Rosefield Solar Farm (EN010158)

Buckinghamshire Council's Comments on the Applicant's Response to Examining Authority's Second Written Questions

Buckinghamshire Council

July 2026

TITLE:
FIGURE 3.8.2
INDICATIVE LOCATION OF PRIMARY AND
SECONDARY CONSTRUCTION COMPOUNDS

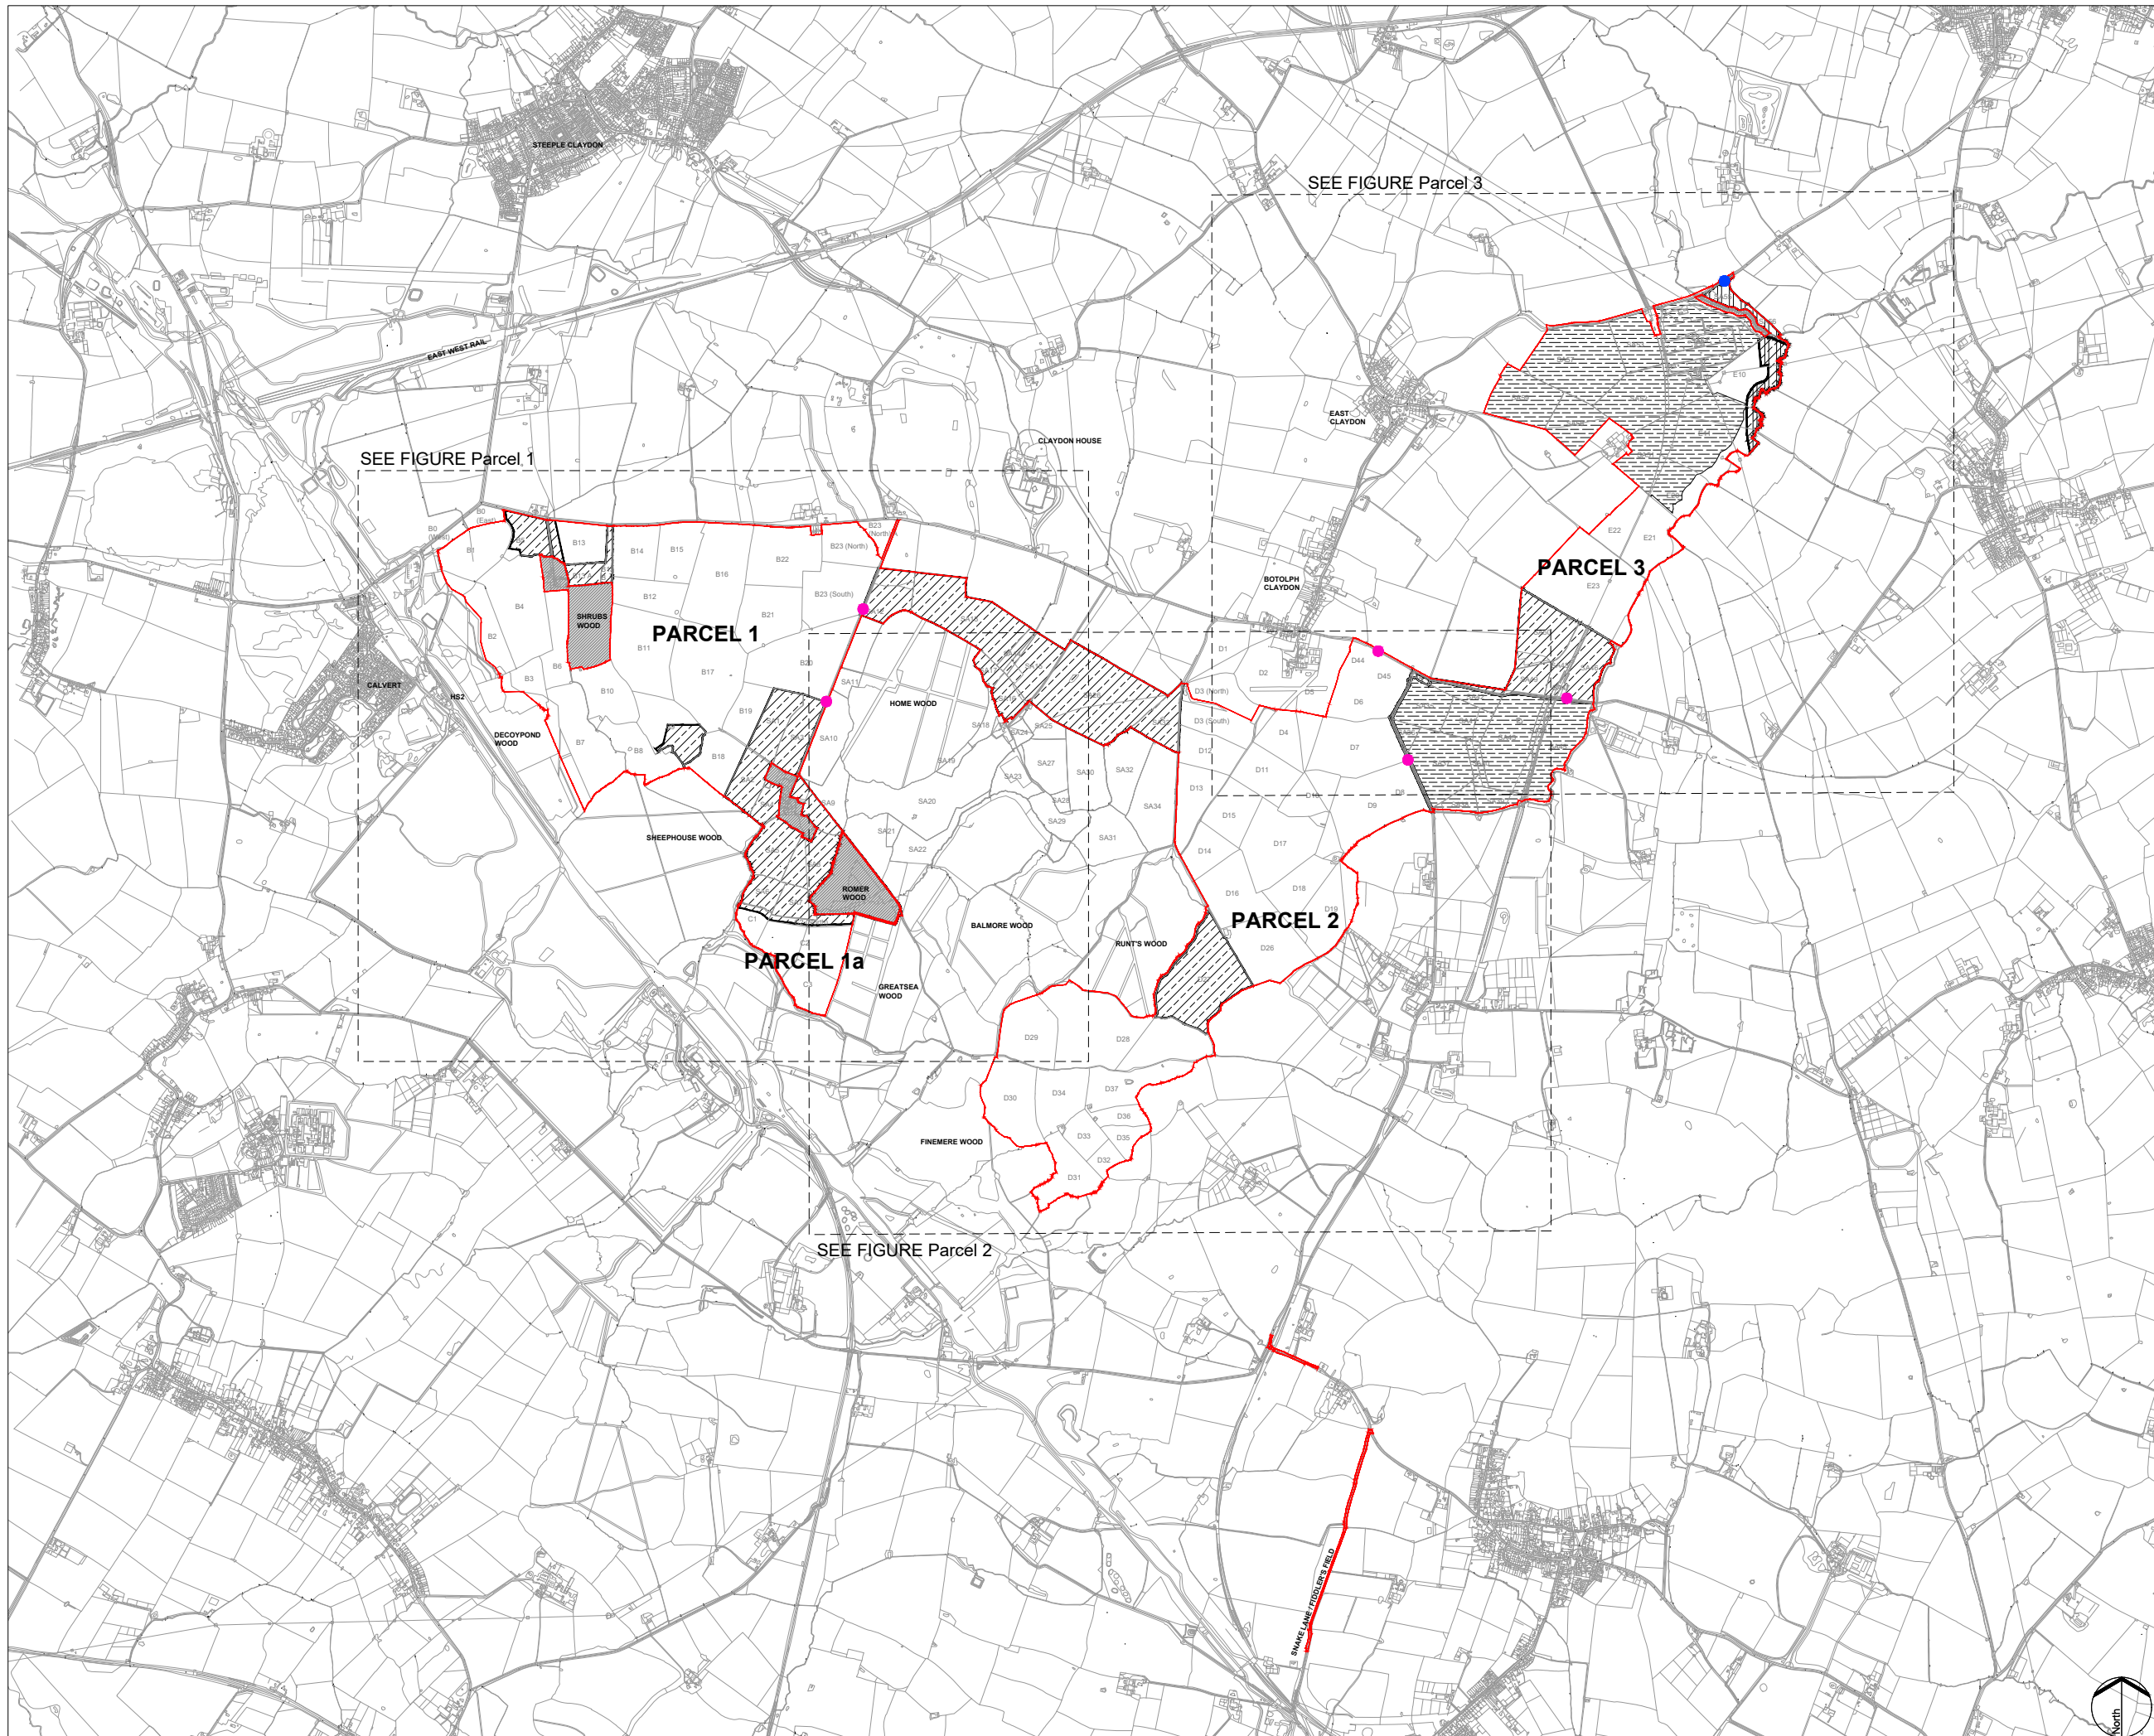
ExQ2 Ref	Question	Applicant's Response	Buckinghamshire Council Comments
Q2.14.1	Primary construction compound in field E21, E22 or E23 - At what stage would the applicant determine whether the primary construction compound in parcel 3 as identified in the Works Plans [REP3-005] and figure 3.8 of Environmental Statement (ES) Chapter 3 Proposed Development Description [REP1-049] would be located in either field E21, E22 or E23? - What factors would inform the decision regarding the location of the primary construction compound and would it be subject to consultation with relevant landowners and tenants? - Aside from the grazing corridor proposed for Field E23 in the	- Following ISH1 the Applicant can commit to moving the Primary Construction Compound out of Field E23 and instead place it within Fields E22 or E21 to mitigate the potential effect for Preston Farms Ltd. This is shown on the revised ES Volume 3, Figure 3.8: Indicative Location of Primary and Secondary Construction Compounds [EN010158/APP/6.3.5] submitted at Deadline 4. Post consent and when compiling the detailed construction schedule once the details of the final design are known, the Applicant would determine the final extent of where the Construction Compound will be positioned within Fields E22 or E21. - The final location of the Construction Compound will be determined within Fields E22 or E21 primarily through consideration of health and safety implications, proximity to flood zones, the best access routes and the position which provides the longest site setup before having to remove and build over the existing compound area. It is likely that most of Field E21 will be used as the Primary Construction Compound for Parcel 3, however this will be confirmed at post-consent stage. This will be discussed with relevant landowners and tenants prior to confirming the location. - As confirmed in the response to Point 1 above, the Applicant can commit to removing Field E23 from the Primary Construction Compound siting zone. Furthermore, the Preliminary Biosecurity Note [EN010158/APP/8.28] (which has been prepared in response to the additional biosecurity details provided by Preston Farms Ltd and TCS Biosciences Ltd at Deadline 3 [REP3-067]) sets out the approach to biosecurity throughout the construction phase. Site Access Procedures would be in place to ensure biosecurity protocols are	This is noted. The Council takes this opportunity to reinforce the request made at ISH3 and accepted by the Applicant to provide further granular analysis in the reporting that underpins the findings of the Population assessment, through a technical appendix. The Council would expect information set out here to be reflected in the description of relevant mitigation and design connected to the relevant receptor (i.e. Preston Farms Limited and TCS Biosciences). The Council will comment further, as appropriate, once the requested appendix is made available to the Examination.

ExQ2 Ref	Question	Applicant's Response	Buckinghamshire Council Comments
	Design Commitments [REP3-010], what other mitigation measures are proposed to address the potential effects of the compound on the use of field E23 by Preston Farms Limited? In answering this question, have regard to the additional information provided at deadline 3 by Preston Farms Limited regarding its use of field E23 [REP3-067].	followed, enforcement of these measures would be a contractual obligation with site contractors.	
Q2.14.2	Knowl Hill Farm – layout of the proposed development Provide further explanation and justification of the proposed layout of the proposed development in the vicinity of Knowl Hill Farm having regard to matters raised in Mr Claridge's deadline 3 submission [REP3-069]. The Examining Authority (ExA) notes that the applicant's response to issue specific hearing 1 (ISH1) action point 31 on this matter [REP3-049] reiterates its position that the layout and use of fields B18 and B19 was informed by the Residential Visual Amenity Assessment [APP-114]. Did the applicant also consider the implications for farming operations in determining the layout? If so, identify where this is referenced in the examination library. If not, why not?	The Applicant has provided a full response to Action Point 31 in the Written Summary of Applicant's Oral Submissions at Issue Specific Hearing 1 (ISH1) [EN010158/APP/8.16] [REP3-049] to clarify the design reasons underlying the proposed layout in Fields B18 and B19. The Applicant has set out in the Written Summary of Applicant's Oral Submissions at the Compulsory Acquisition Hearing 1 (CAH1) [EN010158/APP/8.7] [REP1-107] how implications for the Claridges' farming operations were considered in the design of the Proposed Development, this includes the following: - The Applicant has included an indicative track across plots 3/11, 3/13, 3/14, 3/15, 3/16, 3/18,4/1 and 4/2 which can be utilised by the Claridge family for farm access purposes to assist with their movements around the farm holding. The final choice of corridor is referenced at paragraphs 5.5.28 and 5.5.29 of the Design Approach Document [EN010158/APP/5.8.3] [CR1-014]. - During design stages 1 and 2, a southern cable route and construction access track option located south of Home Wood was considered. However, among the factors taken into consideration when adopting the northern option at Design Stage 3 was the ability to keep construction traffic further from Knowlhill Farm thereby limiting traffic disruption to the Claridge family. - In order to avoid access to Parcel 1A which would pass through land which will continue to be farmed by the Claridge family, a new access route around Romer Wood (plot 2/7) was included at Design Stage 3, which follows the existing HS2 access route. This removes the need to pass via Knowlhill Farm via plots 2/3 and 2/4 unless necessary for reasons beyond the Applicant's control e.g. the access route through plot 2/7 is obstructed by HS2 works. This is included at paragraph 5.5.31 of the Design Approach Document [EN010158/APP/5.8.3] [CR1-014]. The loss of B18 from agricultural use would be compensated via a land swap agreement for which Heads of Terms have been signed and the solar PV proposed in Field B18 does not restrict the use of adjacent land. As set out in ES Volume 2, Chapter 14: Population [EN010158/APP/6.2.4] it is	Noted. The Council takes this opportunity to reinforce the request made at ISH3 and accepted by the Applicant to provide further granular analysis in the reporting that underpins the findings of the Population assessment, through a technical appendix. The Council would expect information set out here to be reflected in the description of relevant mitigation and design connected to the relevant receptor (i.e. Knowl Hill). The Council will comment further, as appropriate, once the requested appendix is made available to the Examination.
